From: Neville, Julie <Julie.Neville@lancashire.gov.uk>
Sent: 09 July 2025 13:35
To: Planning
Subject: 3/2025/0377 Fields Farm Mearley Pendleton BB7 1PU
Attachments: 3 2025 0377 Overlay.pdf

Reference 3/2025/0377
Location Fields Farm Mearley Pendleton BB7 1PU
Proposal Prior approval for the proposed change of use of a former agricultural building to one dwellinghouse under Schedule 2, Part 3 Class Q of the GPDO.

Lancashire County Council Public Rights of Way Team is not supportive of the plans and provides the following.

project	project number	drawing number
fields farm	25.07	PL.0
name	location plan	
scale	date	status
1:1250 @ A1	may 2025	planning
		revision
		C

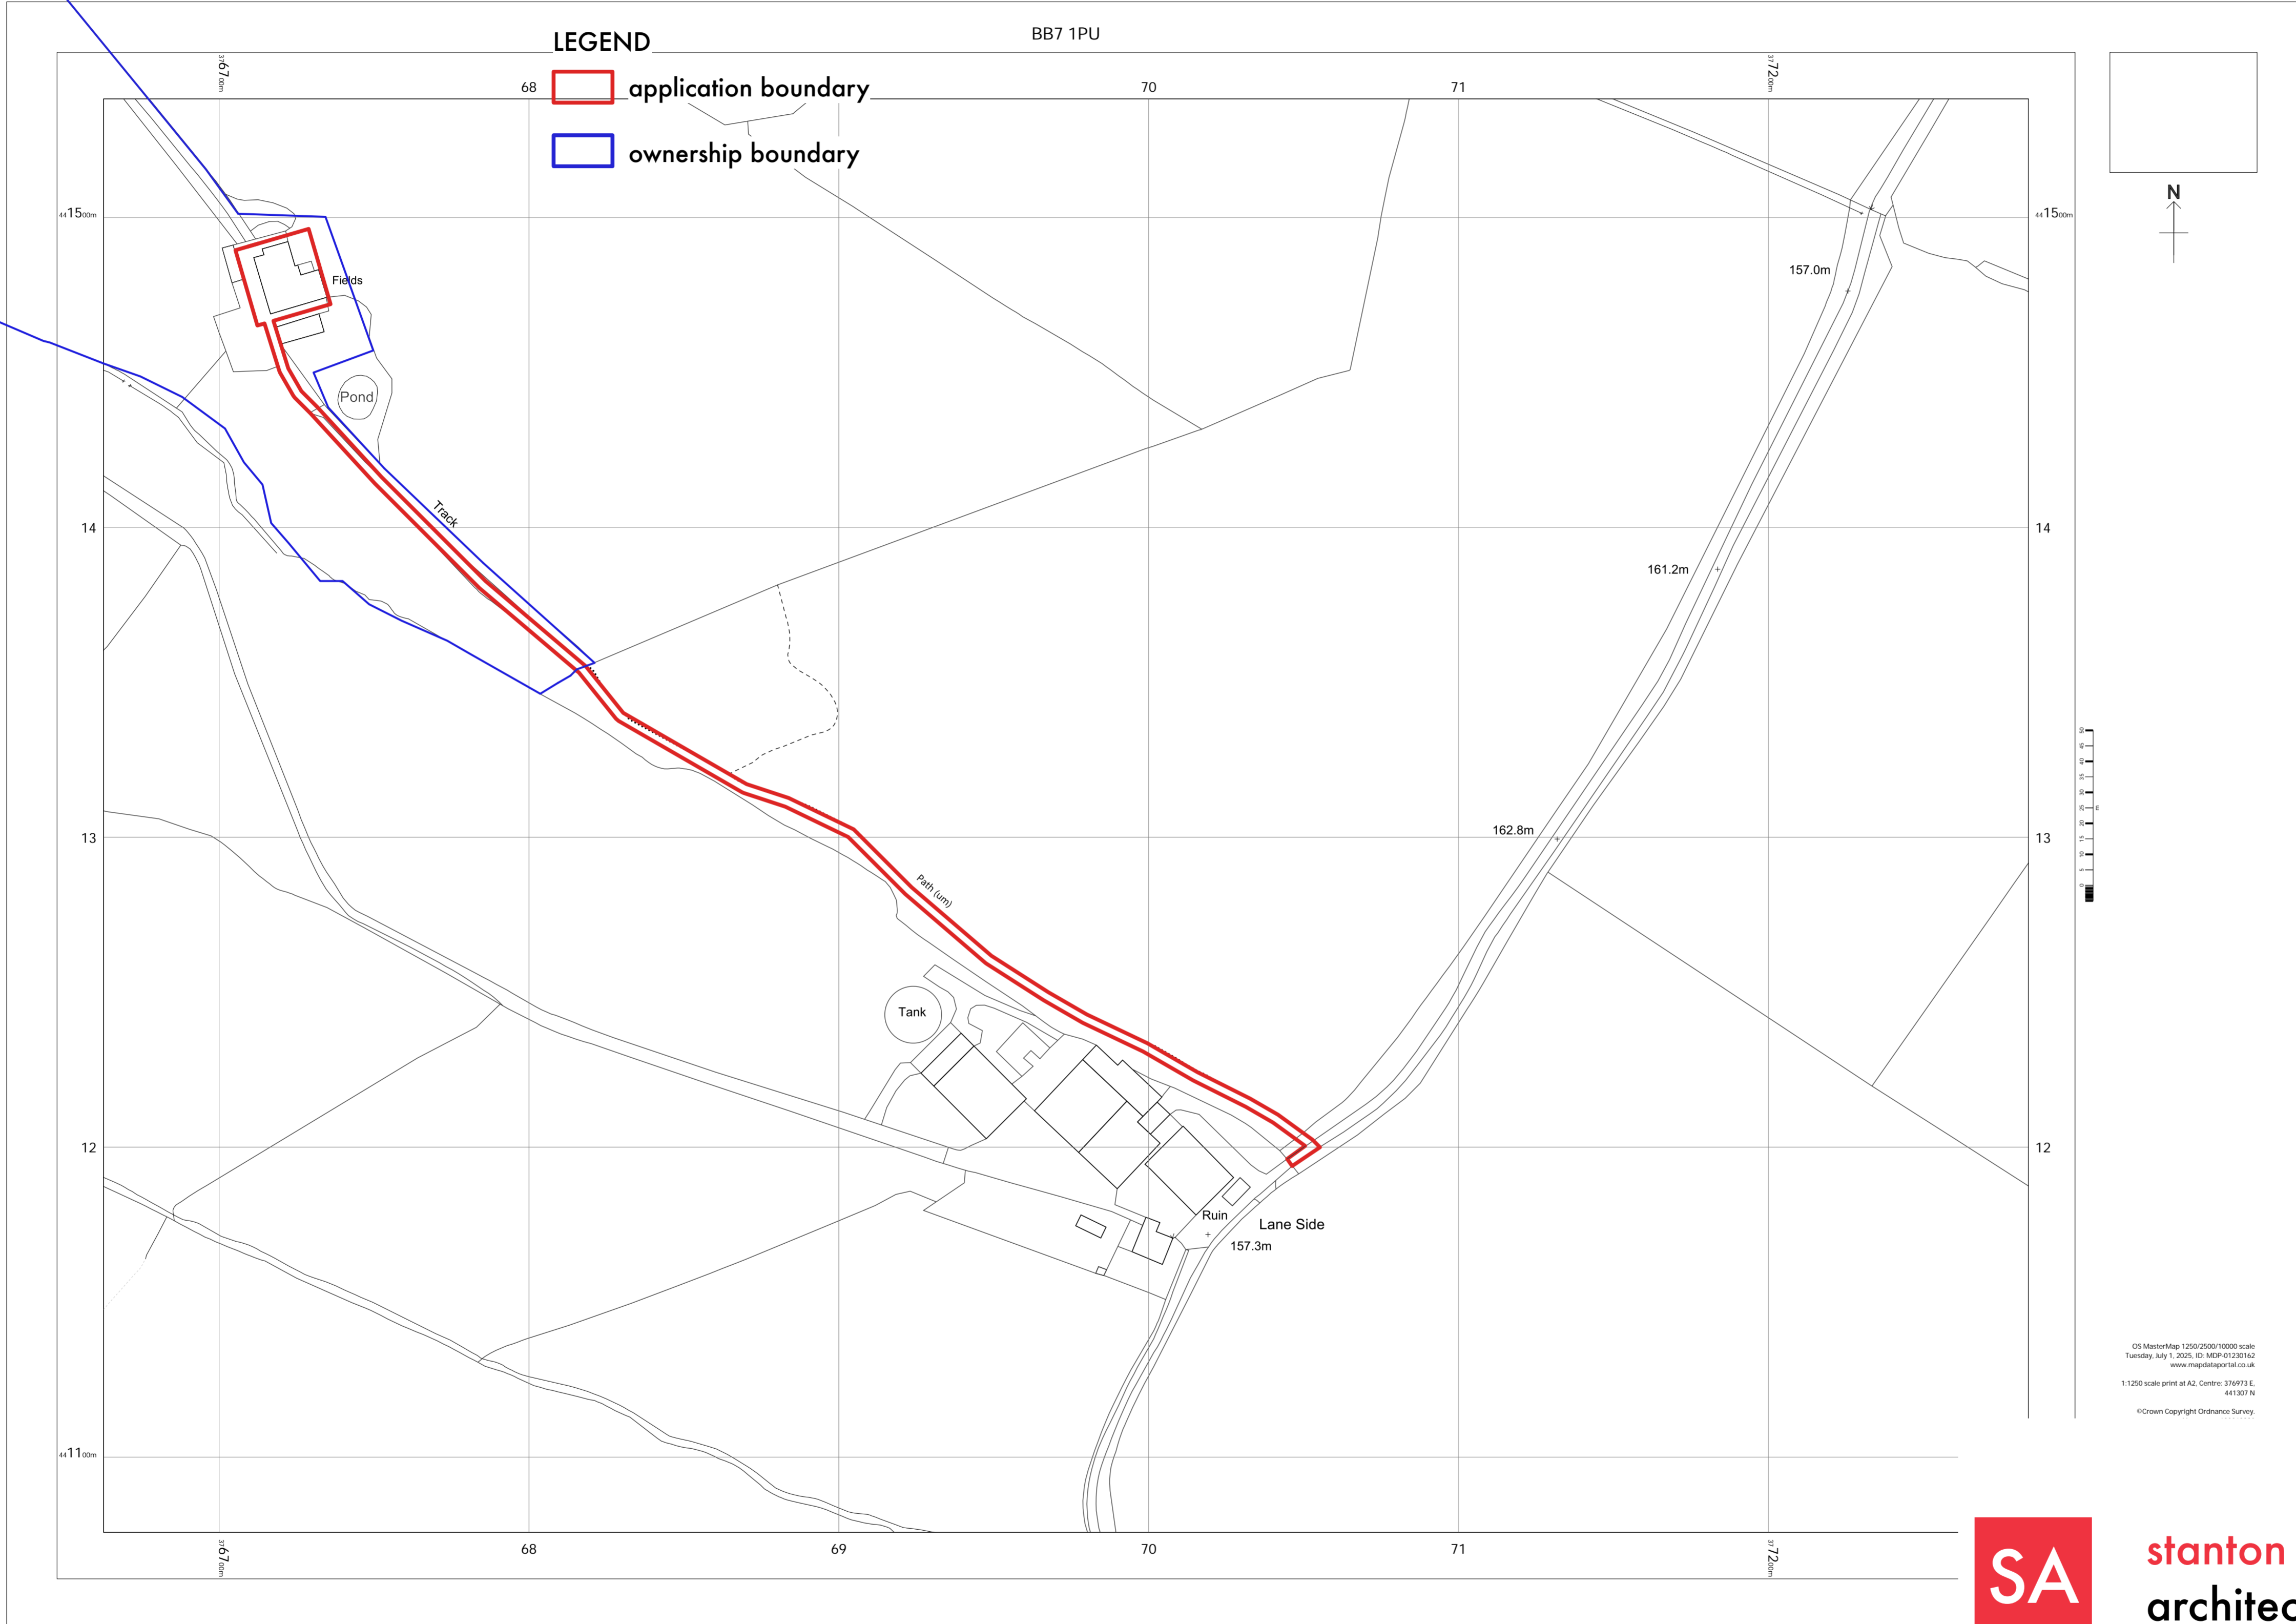
Footpath FP0324004 is recorded as running along the agricultural track to the proposed development, as shown on the attached overlay. The Public Right of Way team is responsible for the surface being in a condition that is safe and fit for pedestrians, it does not maintain the route to a standard that is appropriate for vehicle use, nor does the Lancashire County Council Public Right of Way team wish to see the route deteriorate because of an increase in vehicle usage on the unsealed surface.

The Lancashire County Council Public Rights of Way team have no record of any public vehicular rights along the agricultural track. The applicant should be certain that they have private vehicular rights along this public path before driving on it either during construction or for subsequent access. Without private vehicular rights or permission from the owner it is a criminal offence to drive a motor vehicle on the public path.

The infringement or obstruction of the existing public rights would be a criminal offence and one that would be subject to enforcement should it be impeded. To prevent this from occurring the right of way should always remain clear, not to be excavated nor used to park or store materials, vehicles or machinery.

Any changes in ground level or installation of drainage should ensure that surface water is not discharged onto the public right of way either within the proposed development site or in close proximity – this is to ensure public rights of way are not exposed to potential flooding or future maintenance issues.
